**Consultation Response from Alan Smith,
KC Waste Strategy (Refuse & Recycling)**

2025/90548 78, John William Street, Huddersfield, HD1 1EH

**Change of use and alterations to convert offices to 14 apartments (use class C3)
(Listed Building within a Conservation Area)**

Date Responded: 03/07/2025

LOWER GROUND FLOOR

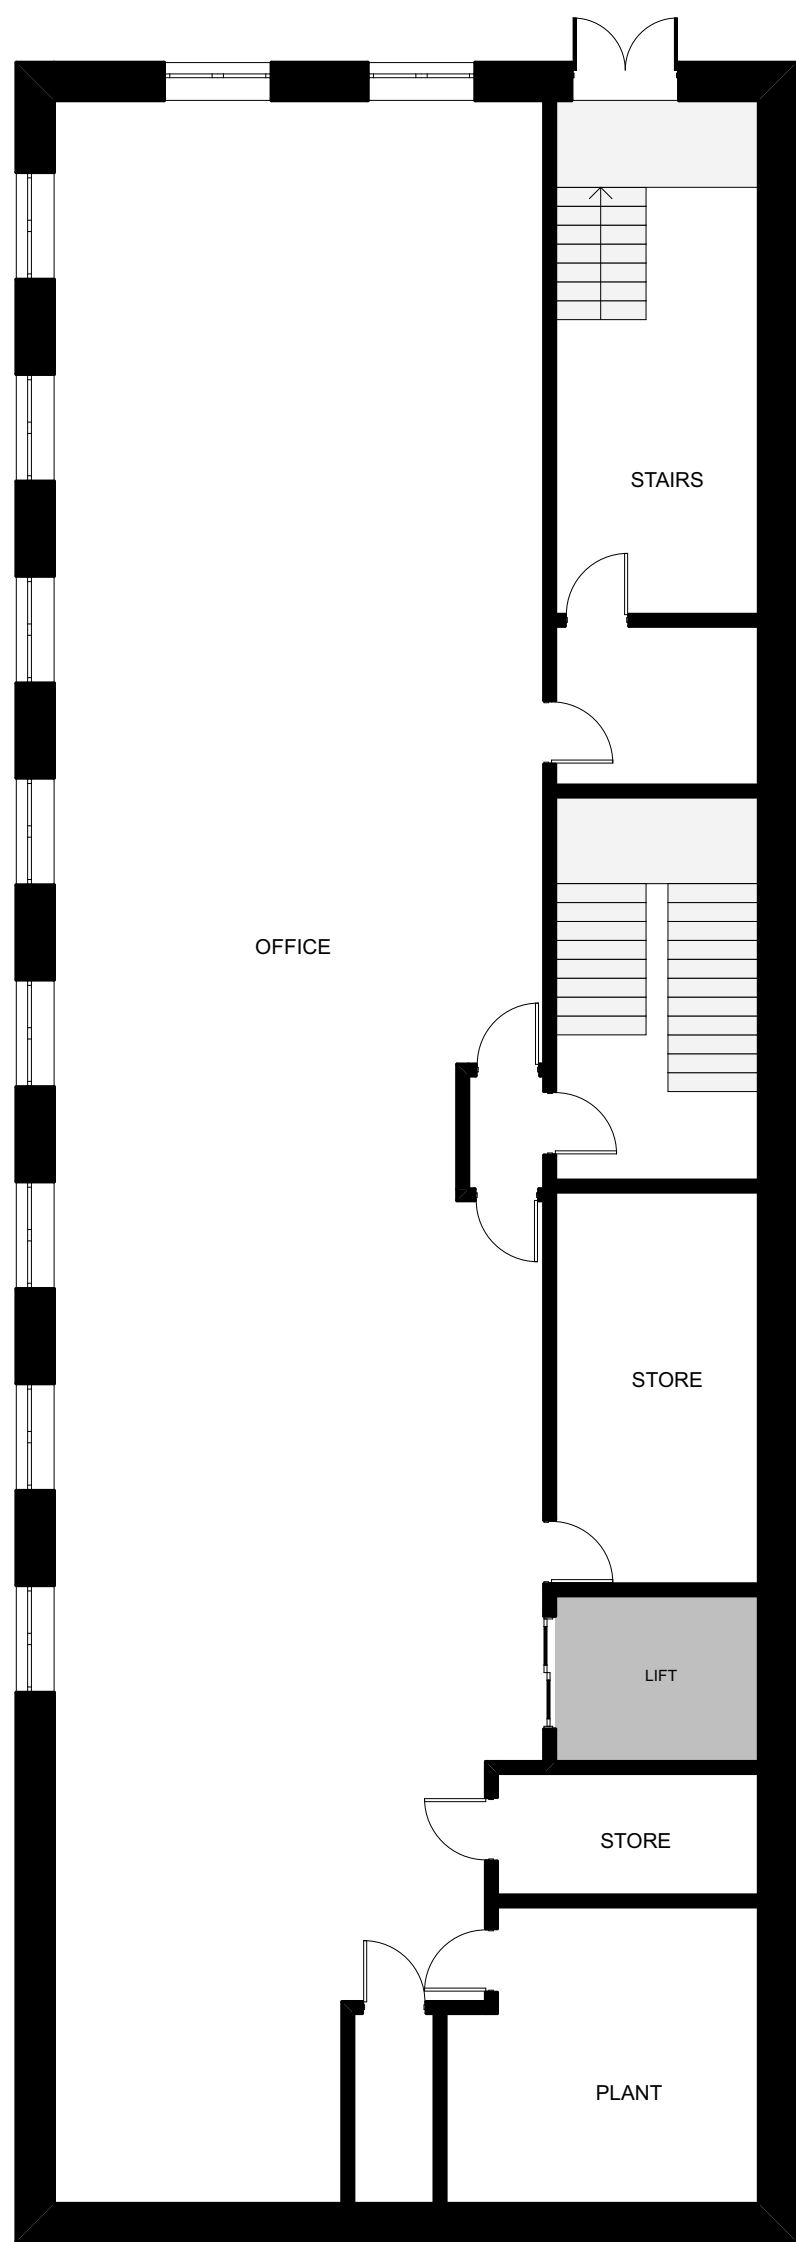
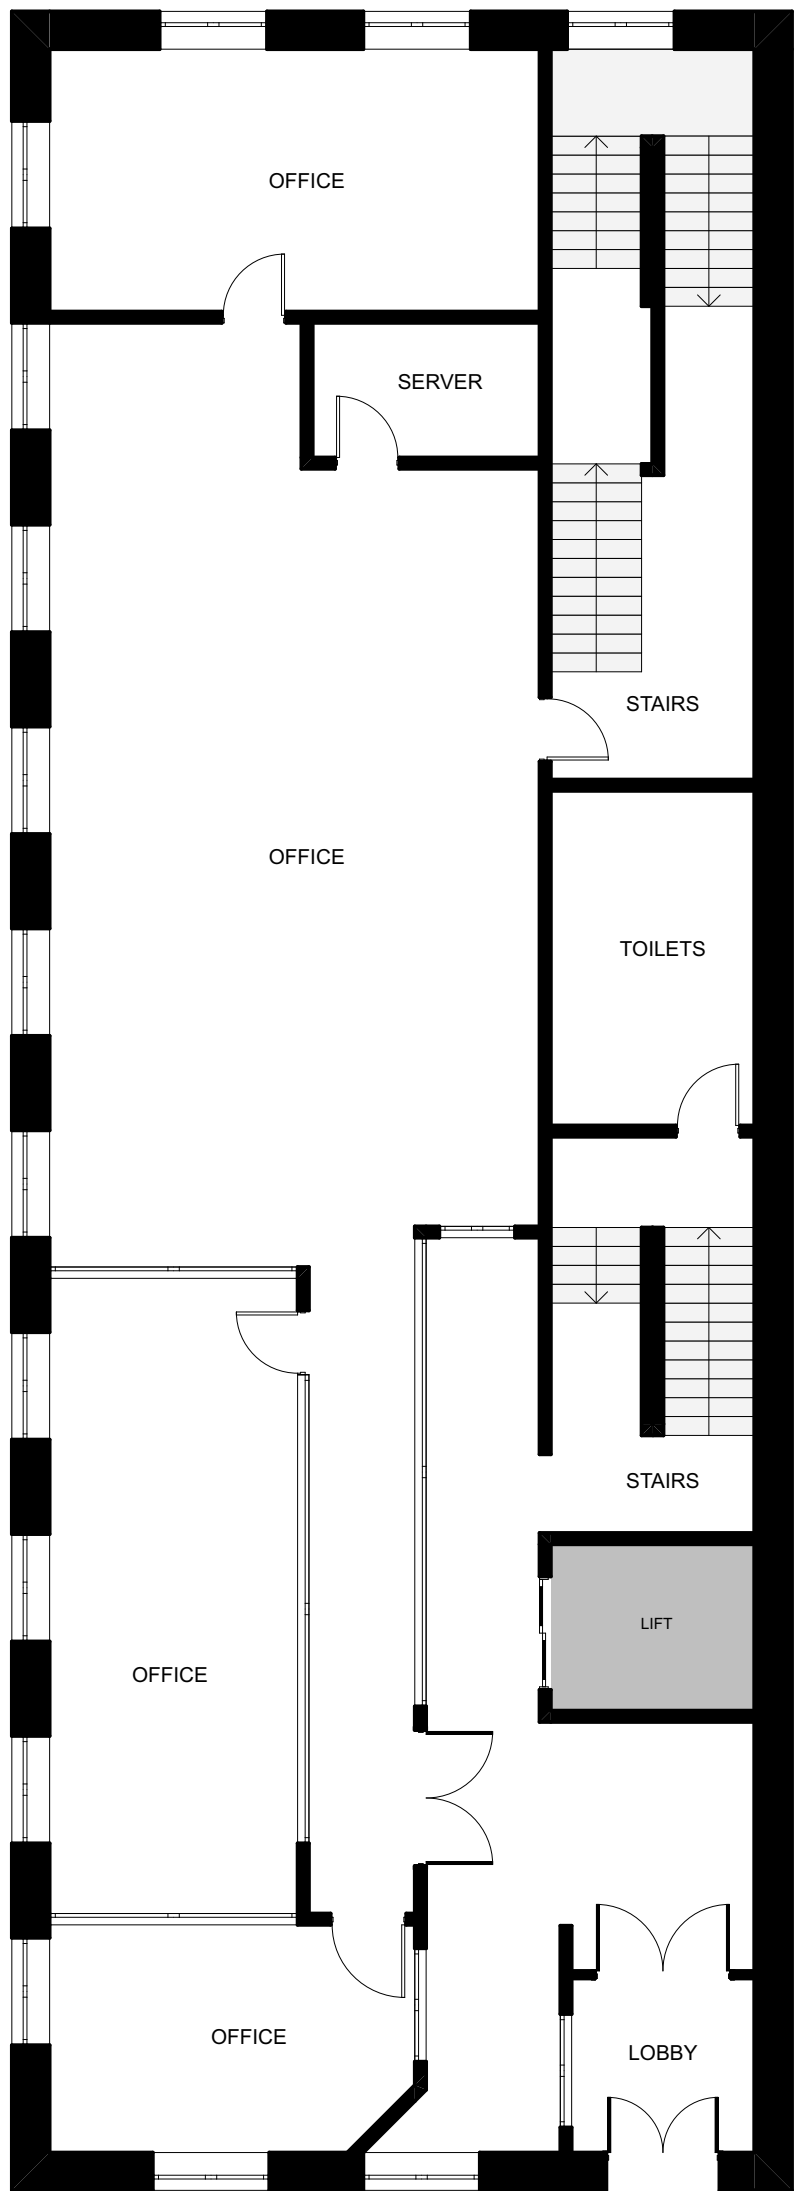
- The application is for the construction of 14 apartments. The plan shows the proposed wheeled bin store located inside the rear entrance to the building off Wood Street. Waste storage capacity for 14 apartments should consist of 180ltr per person x 14 = 2,520ltr. Assuming the use of 1,100ltr wheeled bins this equates to 2.3 containers each for both for residual waste and recycling. So, **5 x 1,100ltr wheeled bins should be acceptable**. Further details of how the crew access the bin store will be required before collections take place.

- The wheeled bin storage area should be secured to prevent unauthorised use. It is important there is adequate room to manoeuvre the bins to Wood Street. The full width of door opening is required to ensure is sufficient clearance for 2 people to empty the wheeled bins. The bin store should be of suitable dimensions to accommodate the bins and constructed in compliance with the details specified in the design guide.

- The internal bin store must comply with fire regulations (refer to BS 5906:2005 Waste Management in Buildings; BS476-22:1987: Fire tests on building materials and structures; and BS EN 1634-1:2008: Fire resistance and smoke control tests for door, shutter and open-able window assemblies and elements of building hardware) for internal compounds.
